CITY OF ALBUQUERQUE

**RE: Broadstone Highlands East Block
Grading and Drainage Plan
Engineer's Stamp Date: 1/24/18
Hydrology File: K15D034C**

Based on the information provided in the submittal received on 1/25/18 the above-referenced Grading and Drainage Plan cannot be approved for Site Plan for Building Permit until the following are corrected:

CONCEPTUAL
GRADING & DRAINAGE PLAN

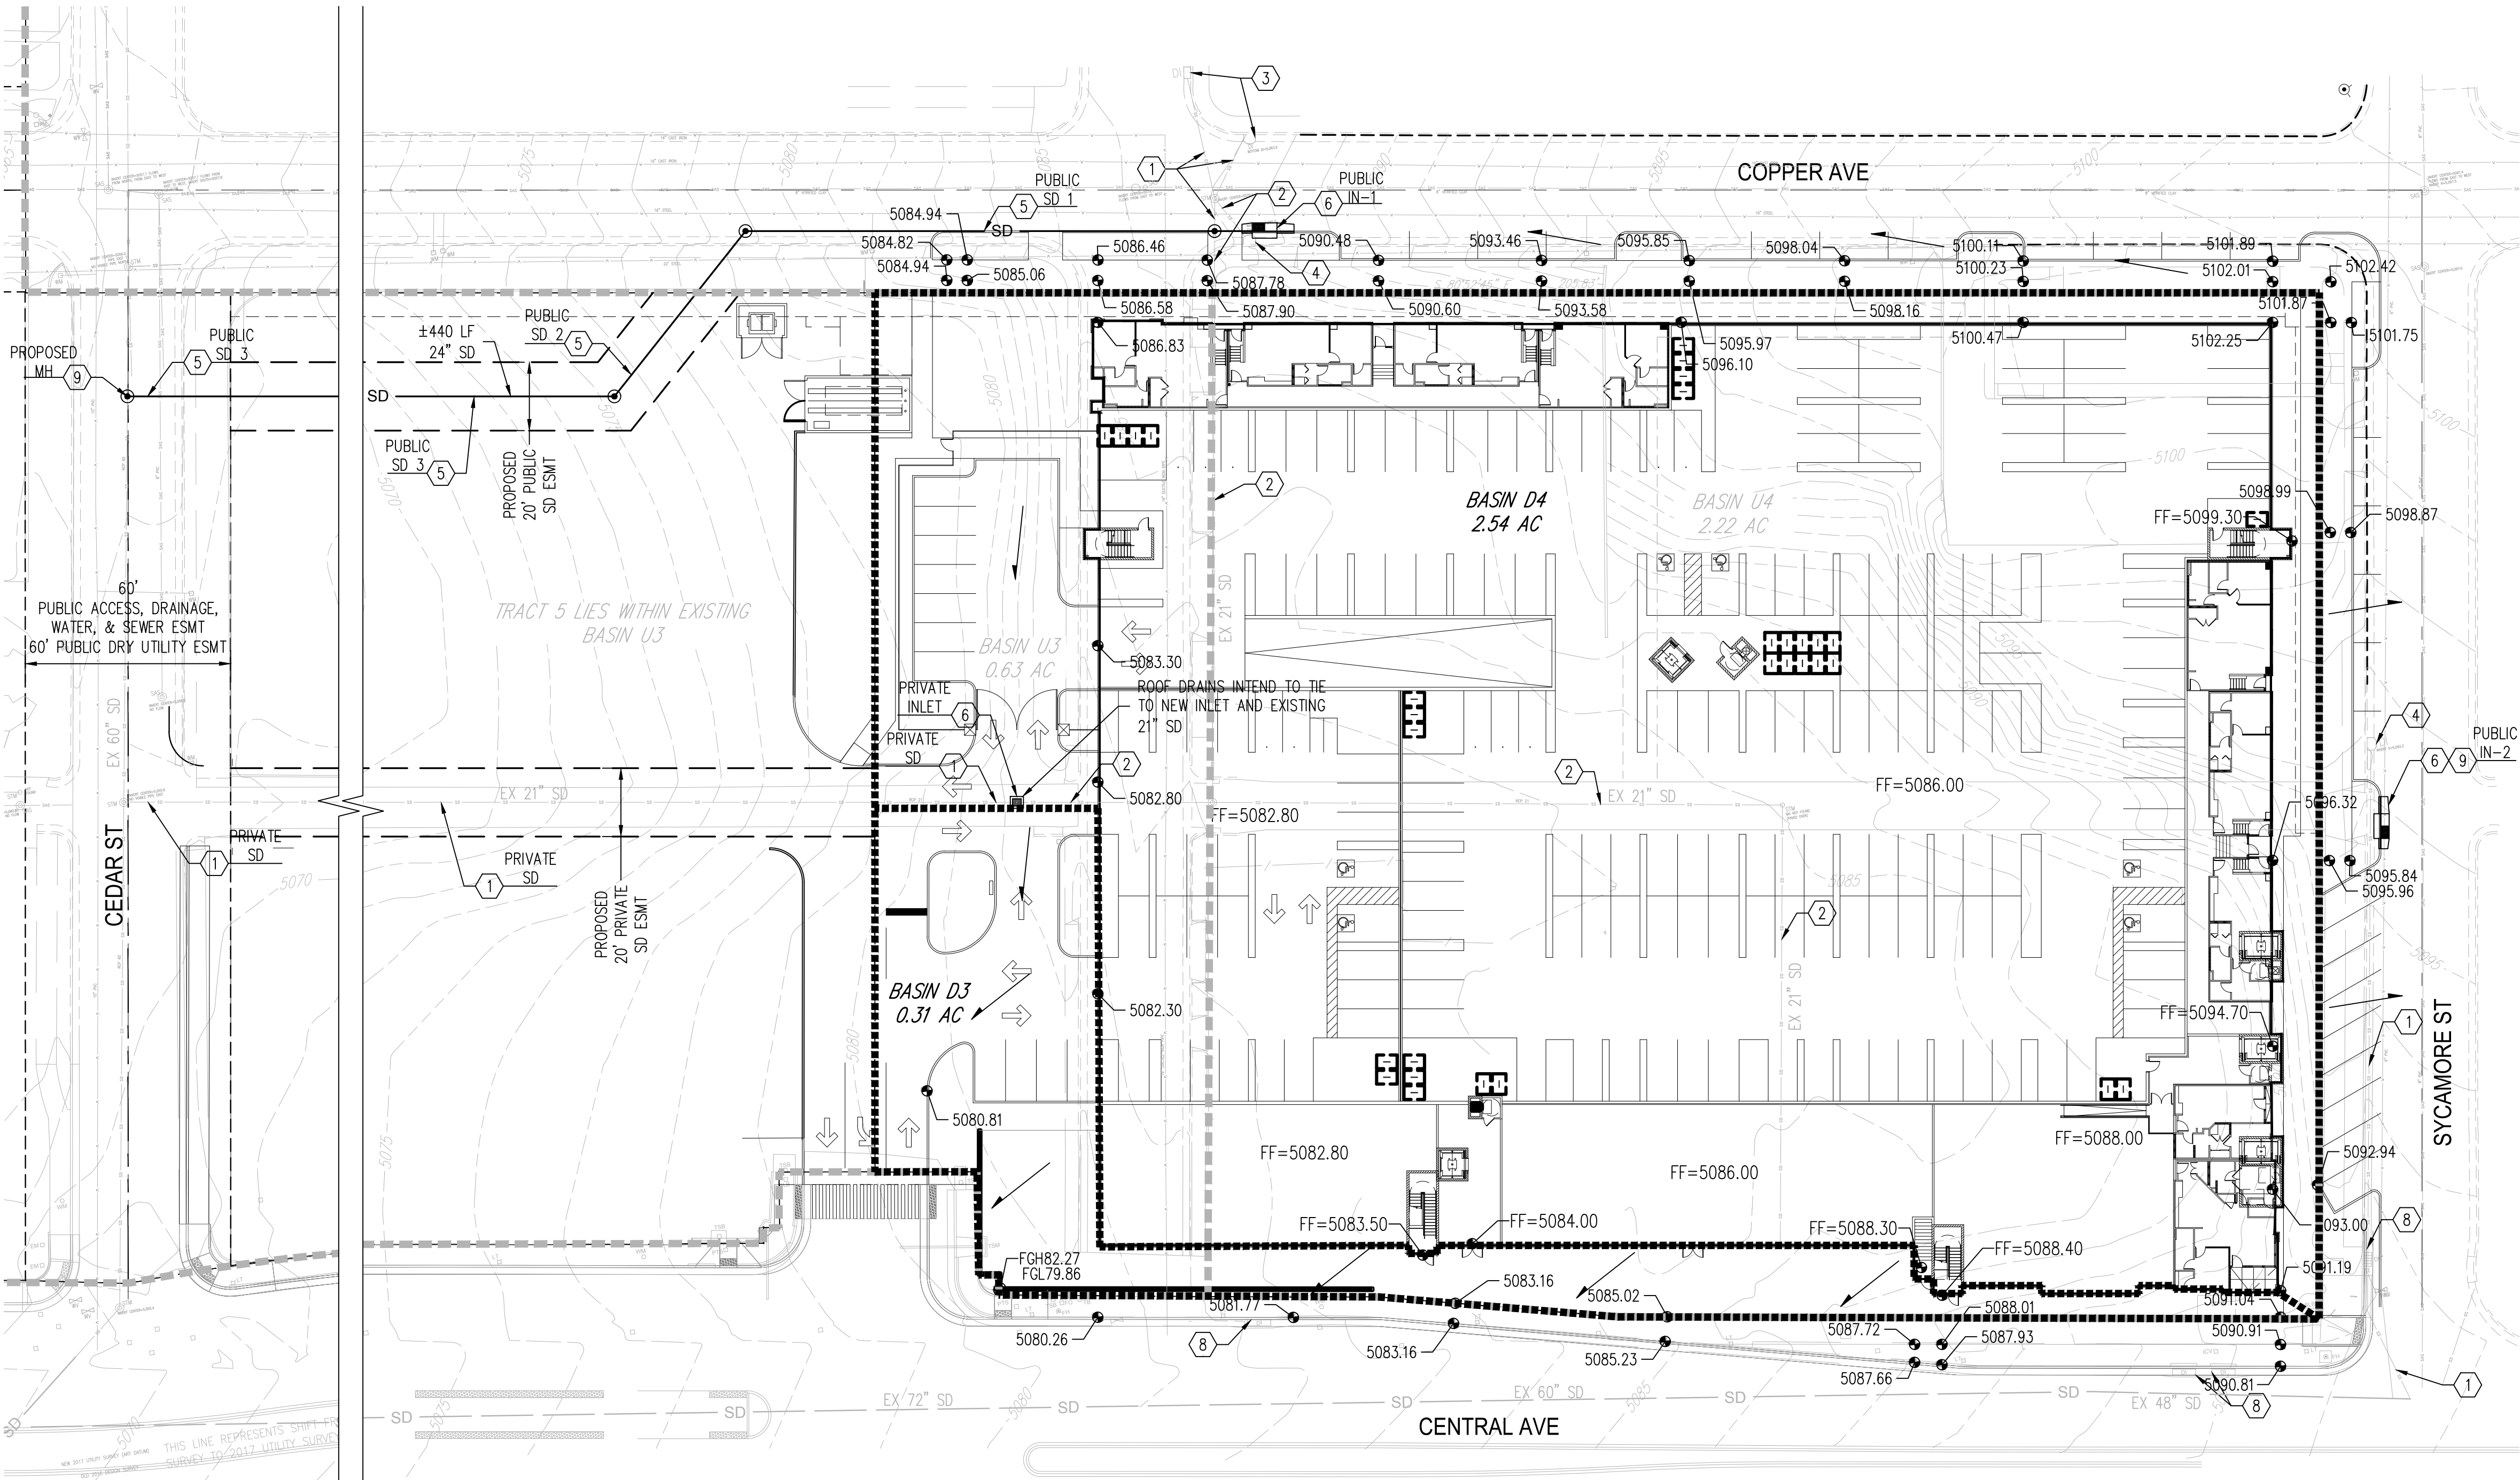
1. Include an off-site subbasin map, including topographic data.
2. Clarify roof drainage and show on plans.
3. Label all Public vs. Private drainage improvements and ensure all improvements in the public ROW are on the infrastructure list.
4. Clarify how the connections to existing storm drain will be made (keyed note 9). If there is no existing manhole to connect to, a new manhole will need to be built and included on the infrastructure list.
5. The new public storm drain easement (recorded) needs to be included on the infrastructure list. Provide a trenching prism at deepest point to evaluate the required width. The width will need to be at least 20' per DPM Ch.22, Section 6, Part C.
